**Tweed Valley Hospital Multi-Deck Carpark
SSD3 AMENDMENT REGISTER****DCR-SSD3**

We issue herewith the list of changes made on the drawings as sent in the nominate transmissions.

Transmittal Date 16.09.2022

FLOOR PLAN - BASEMENT
2

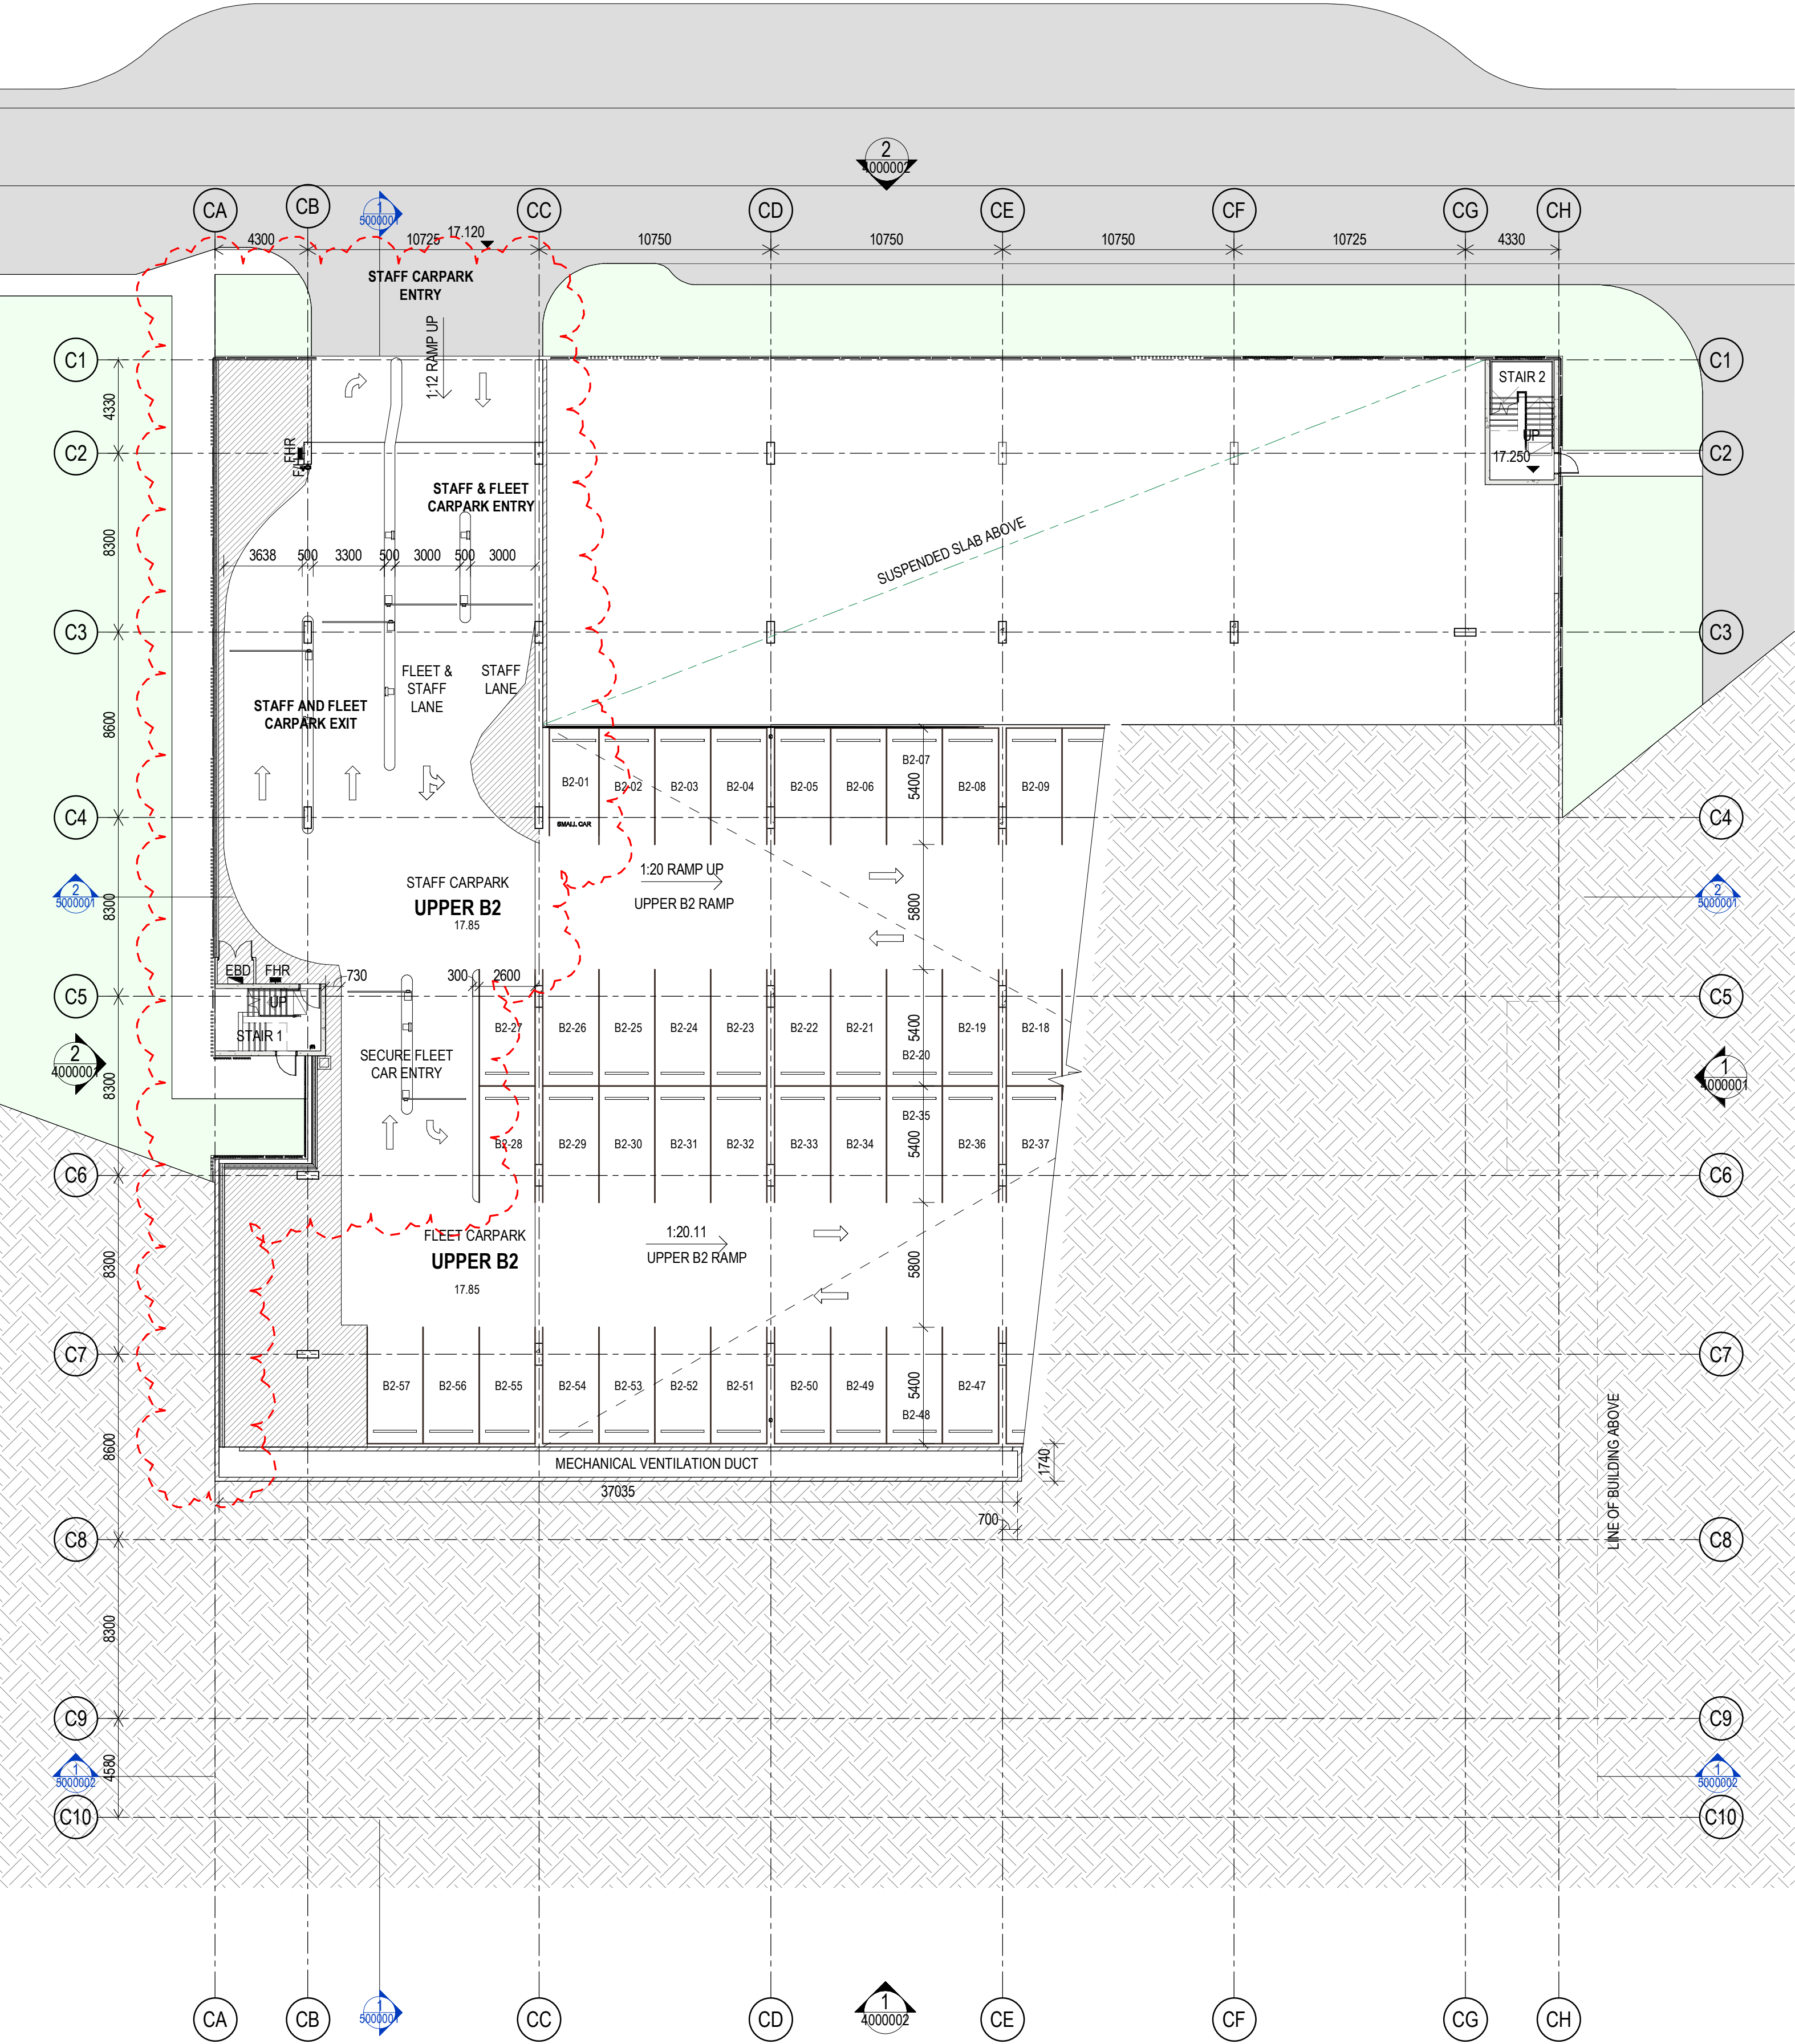
Doc. No.	Document Title	Doc. Rev. #	Doc. Change #	Doc. Change	Notes
MDD-AR-SKE-MCP-20B2001	FLOOR PLAN BASEMENT 2	7	1	Staff and Fleet Vehicle Entry and Exits revised as per Traffic Engineers recommendations for compliant sweep paths	
			2	Parking Bay B2-01 revised to Small Parking Bay as per Traffic Engineers recommendations for compliant sweep paths	
			3	Exit path from Stair 1 revised as part of Design Development	
			4	Crash Barrier shown on Grids CA and CB, part of design development	
			5	Minor planning amendments to services (ie Hose Reels, Hydrants)	
MDD-AR-SKE-MCP-20B1001	FLOOR PLAN BASEMENT 1	7	1	Public Vehicle Entry and Exits revised as per Traffic Engineers recommendations for compliant sweep paths	
			2	Crash Barrier shown on Grids CA and CB, part of design development	
			3	Additional Fire Hose Reels indicated for compliance during design development	
			4	Grid C5 / C6 and CG / CH, equipment for wash bay above shown, part of design development

5	Strip drain shown in lift lobby - part of design development	
			6	Minor planning arrangements to drainage as part of design development	
			7	Mechanical Exhaust duct indicated - part of design development	
			8	Exit path from Stair 1 at Basement Level 2 revised as part of Design Development	
			9	Minor planning amendments to services (ie Hose Reels, Hydrants)	
MDD-AR-SKE-MCP-2000001	FLOOR PLAN GROUND	6	1	Green spine pavement arrangement adjusted - part of design development	
			2	Café Tenancy Space added	
			3	Covered Walkway extended to Café Tenancy. Arrangement amended as part of design development	
			4	Car Wash Bay Space Shown and noted	
			5	Space for Mechanical Exhaust Fans shown in Female	
			6	Operators Office and Fitout adjusted For AS1428.1 compliance	
			7	Minor planning amendments to services (ie Hose Reels, FIP, Hydrants, Mechanical Exhaust Ducts)	
			8	Pay Stations positions revised to be opposite lifts, Grid C9 / C10

DRAWING TITLE			
FLOOR PLAN - LVL 03			
PROJECT No	21192	DRAWN Author	CHECKED Checker
ISSUE 08/09/2022 12:27:07 PM	SCALE @ A1 1:200	SCALE @ A3 1:200	REVISION
DRAWING No MDD-AR-SKE-MCP-2003001			4

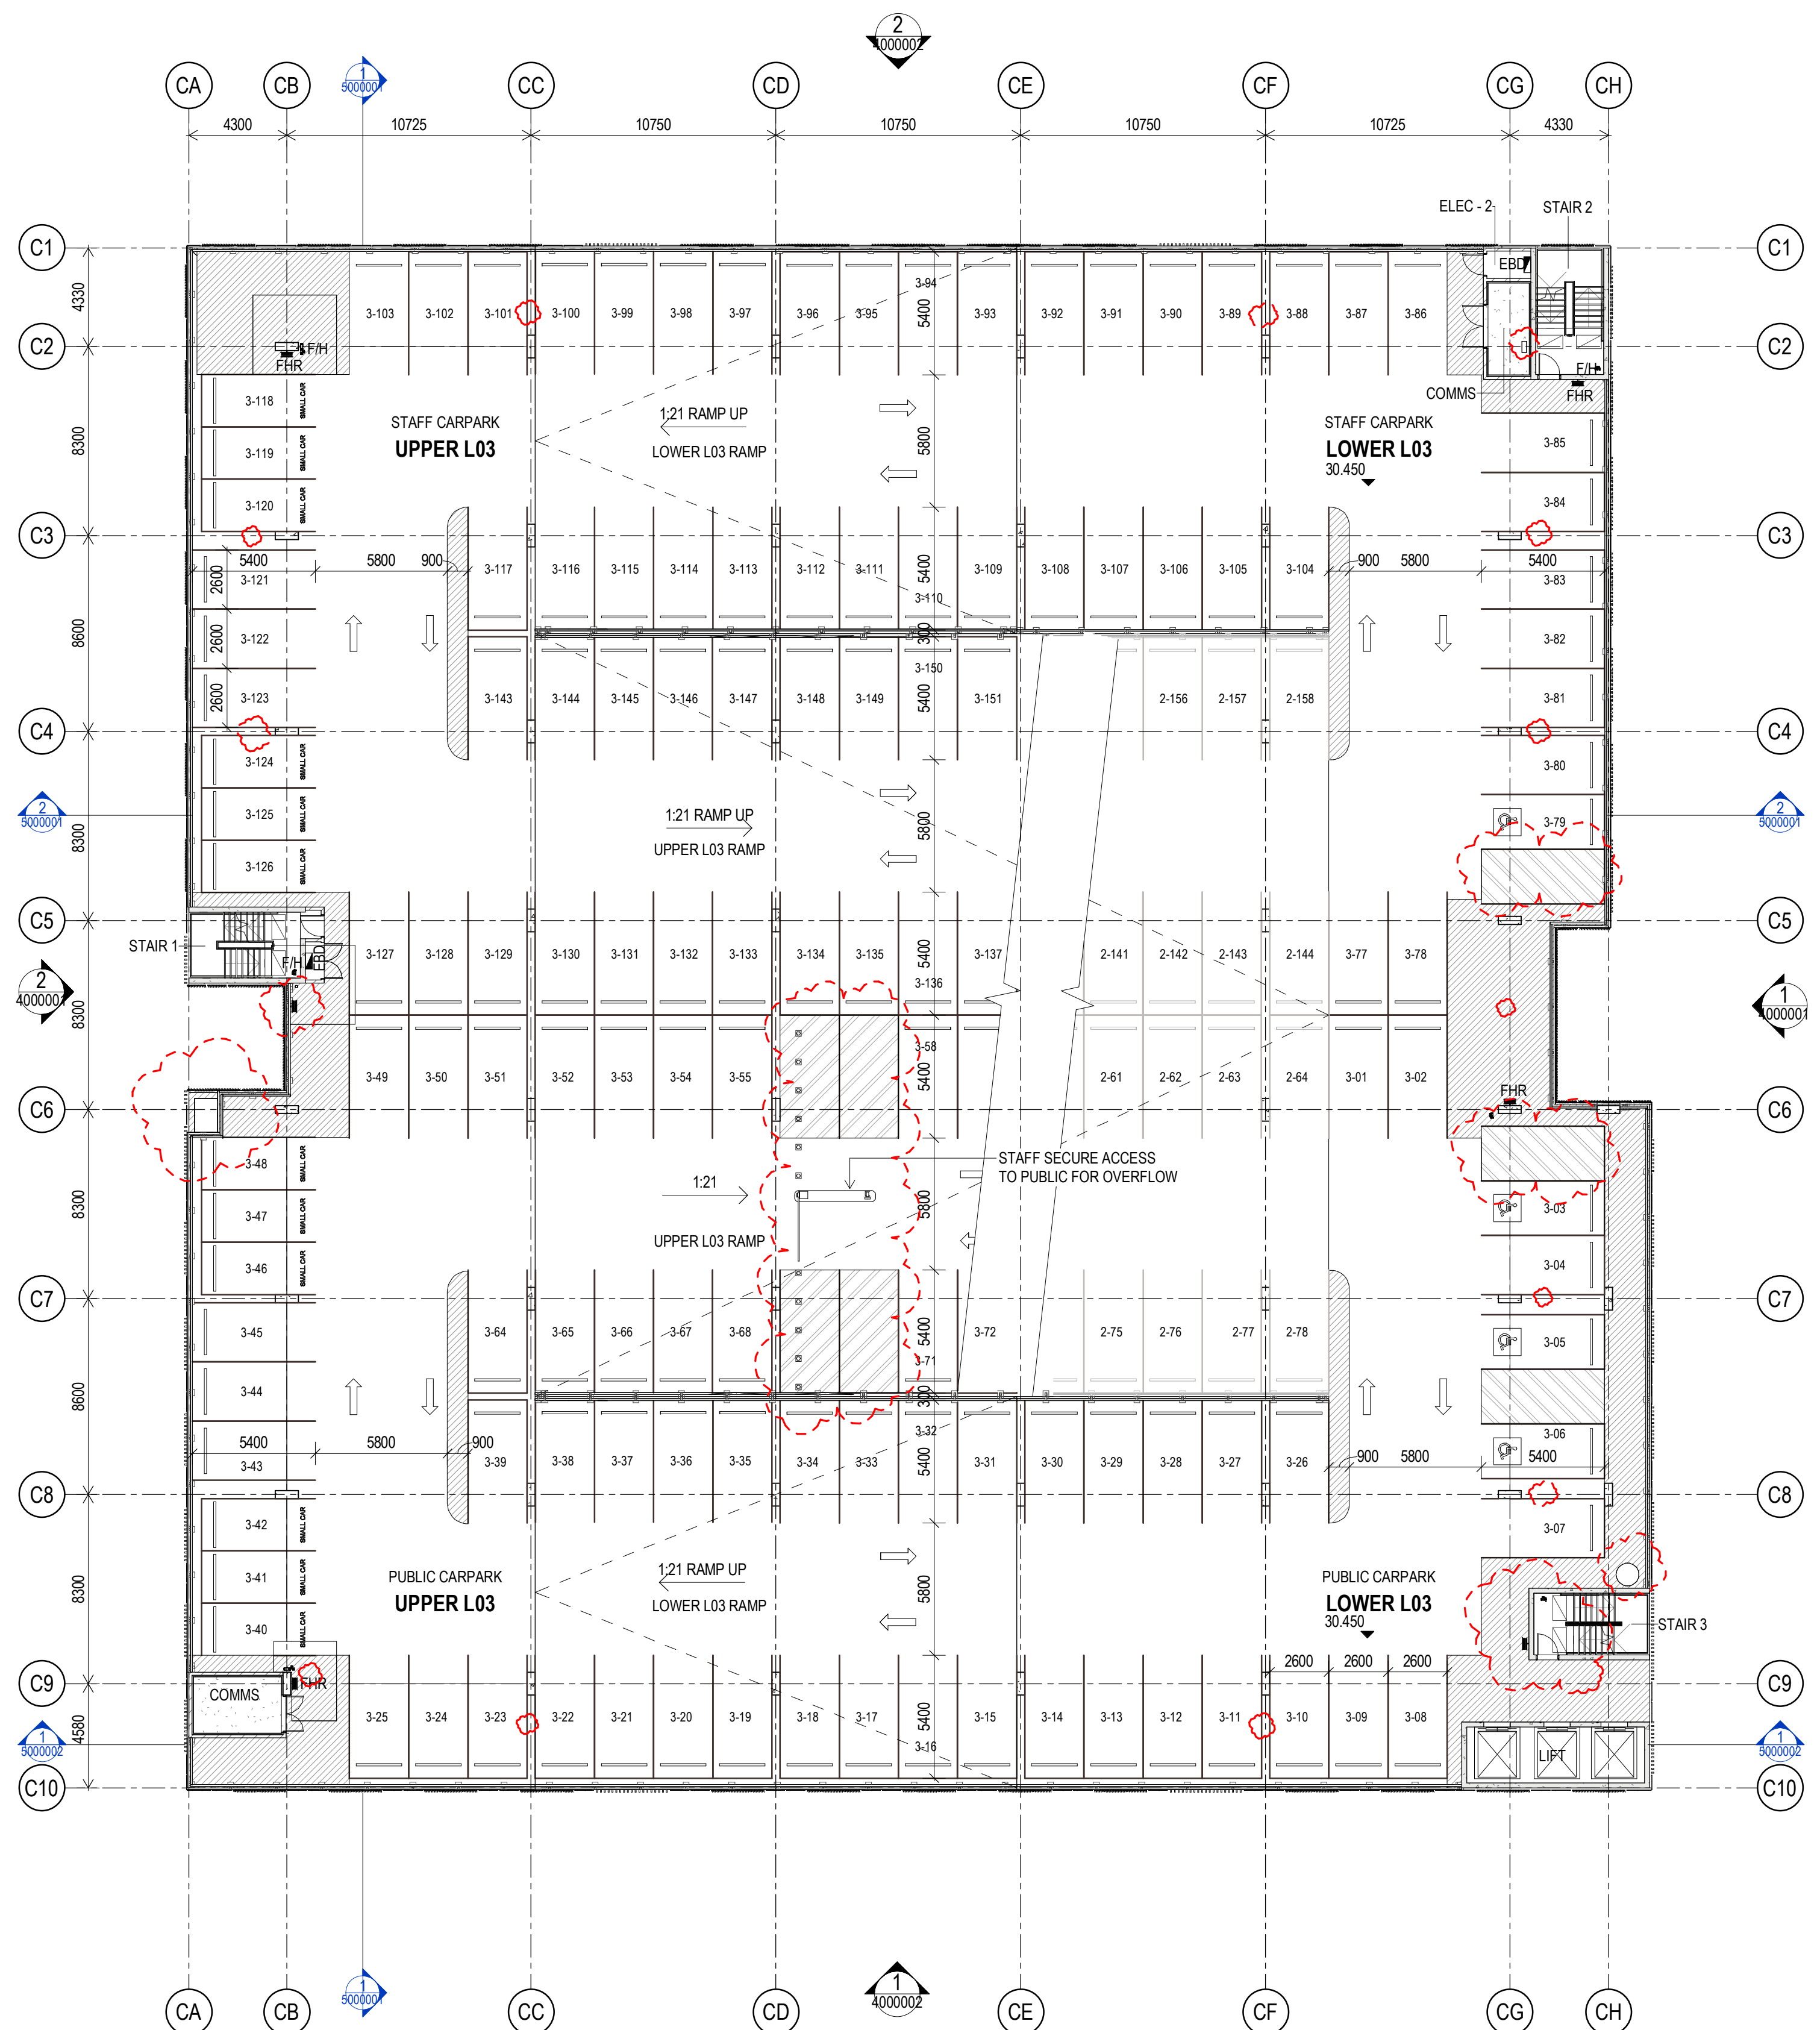
4	Drainage Wastes amended from Circular to square type as part of design development	
MDD-AR-SKE-MCP-2003001	FLOOR PLAN LEVEL 3	4	1	Mechanical Exhaust duct indicated - part of design development	
			2	Accessible parking bay clear zone defined	
			3	Minor planning arrangements to drainage as part of design development	
			4	Staff Parking overflow arrangement amended as part of design development (relocated along Lvl 3 to 4 ramp)	
MDD-AR-SKE-MCP-2004001	FLOOR PLAN LEVEL 4	6	1	Mechanical Exhaust duct indicated - part of design development	
			2	Accessible parking bay clear zone defined	
			3	Minor planning arrangements to drainage as part of design development	
			4	Staff Parking overflow arrangement amended as part of design development (relocated along Lvl 3 to 4 ramp)	
MDD-AR-SKE-MCP-2005002	LIFT OVERUN - LVL5 / ROOF PLAN	6	1	Mechanical Exhaust discharge indicated - part of design development	
			2	General Arrangement and orientation of Solar Structures developed as part of detailed design as per supplier advice
